Application Ref:	3/2020/1003	 Ribble Valley Borough Council www.ribblevalley.gov.uk
Date Inspected:	21/12/2020	
Officer:	RB	
DELEGATED ITEM FILE REPORT:		Decision APPROVAL

Development Description:	Demolition of existing conservatory and construction of single storey extension to the rear. First floor extension to the front and proposed extension to existing front porch.
Site Address/Location:	1 Carr Croft, Rimington, BB7 4EN

SHEET: **PROPOSED PLANS & ELEVATIONS**

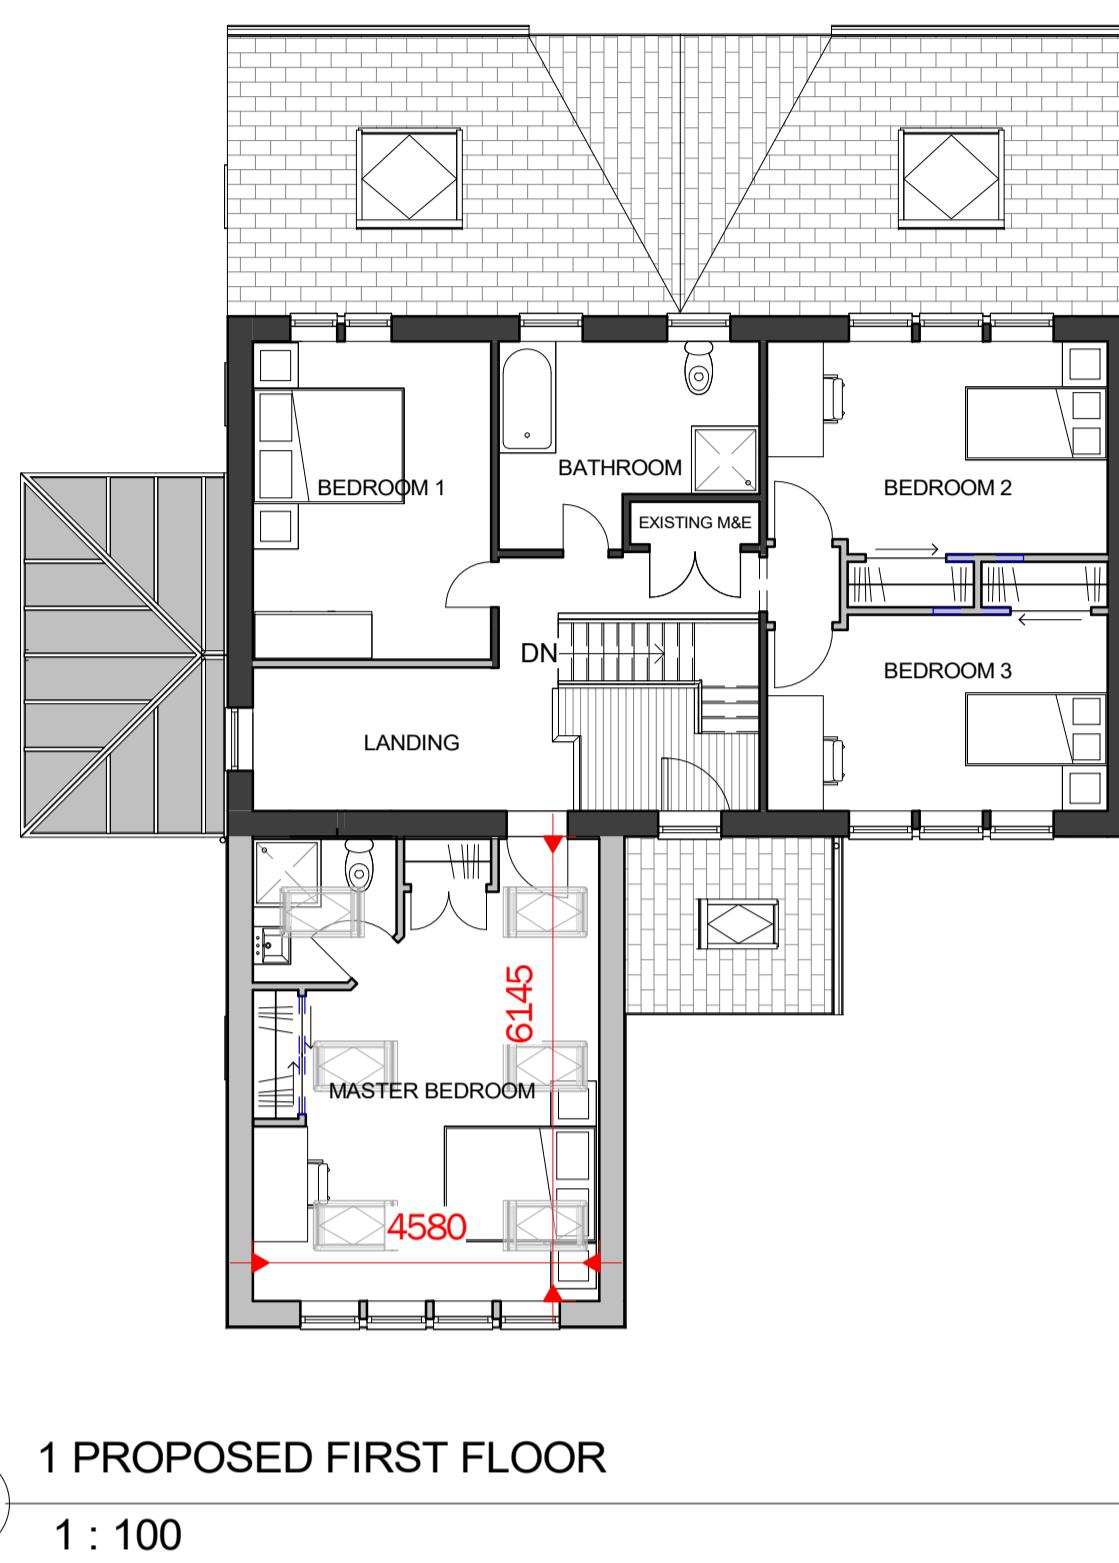
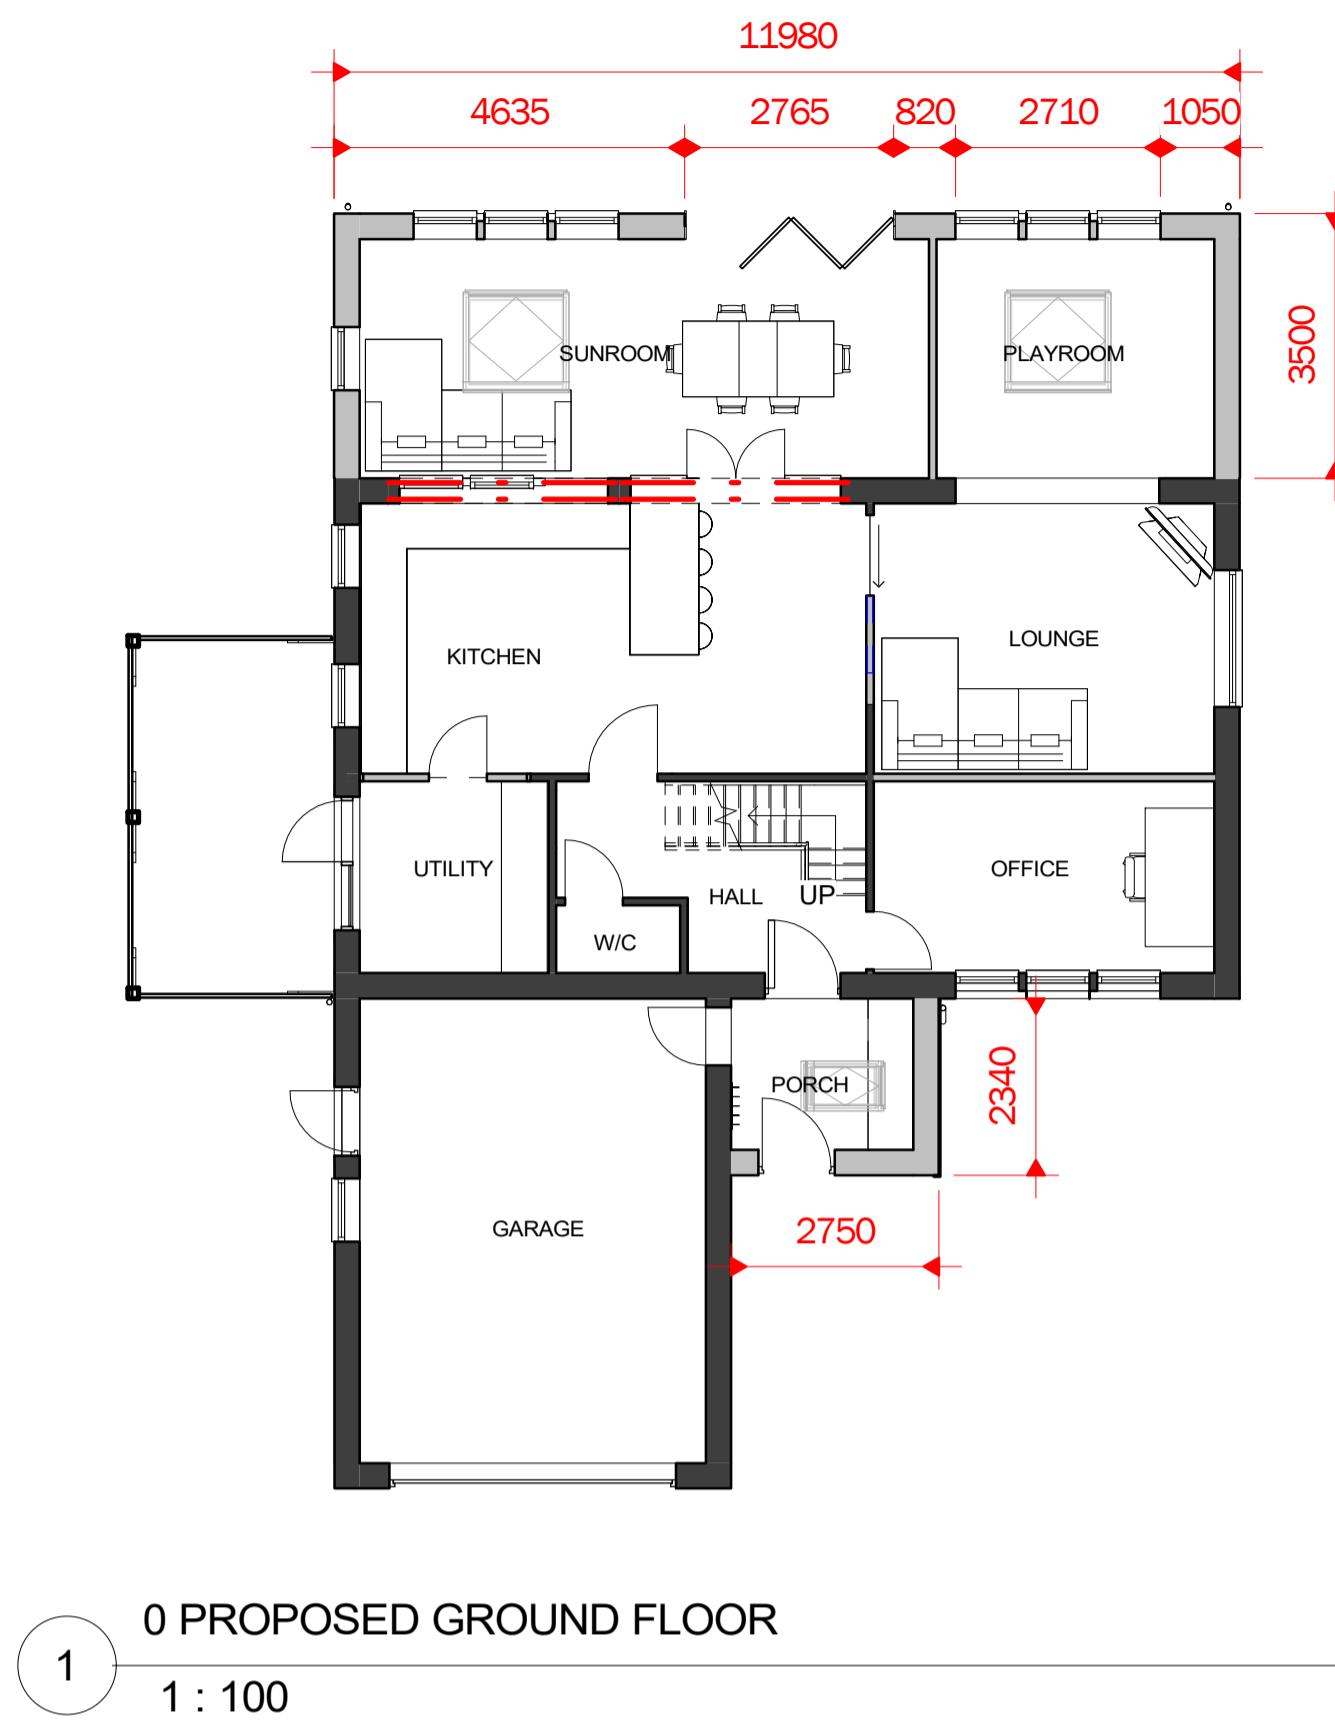
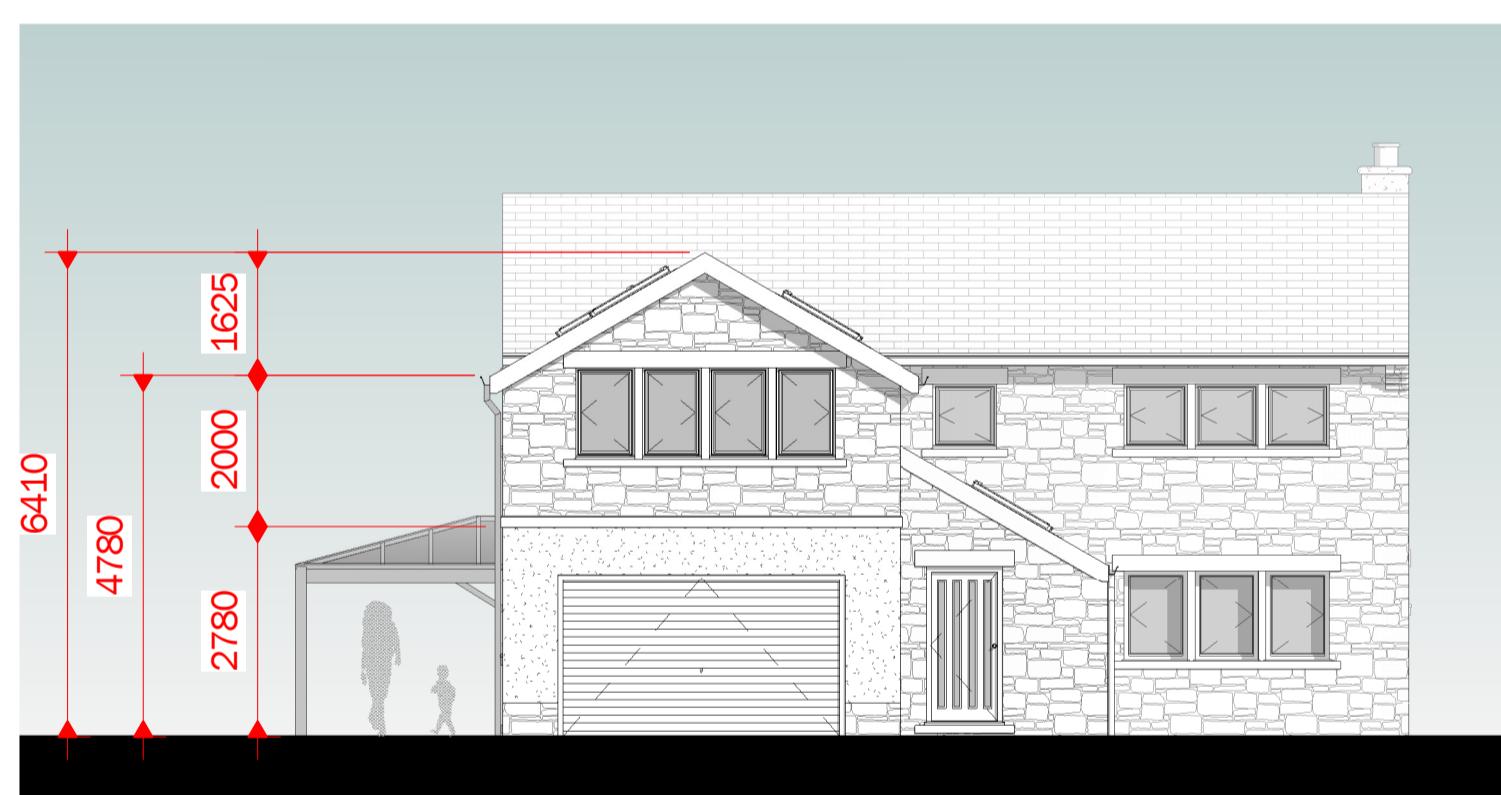
On the main house a first floor window is proposed serving a landing area. This window has the potential to overlook the garden area of Stonecroft therefore it will be condition that this window be obscurely glazed.

The development was originally submitted proposing to have a balcony on the front elevation of the property. It was considered that this design was unacceptable and it was requested for the proposed fenestration to be of a similar appearance to the windows on the main house. The applicant's agent subsequently submitted amended plans which are considered acceptable.
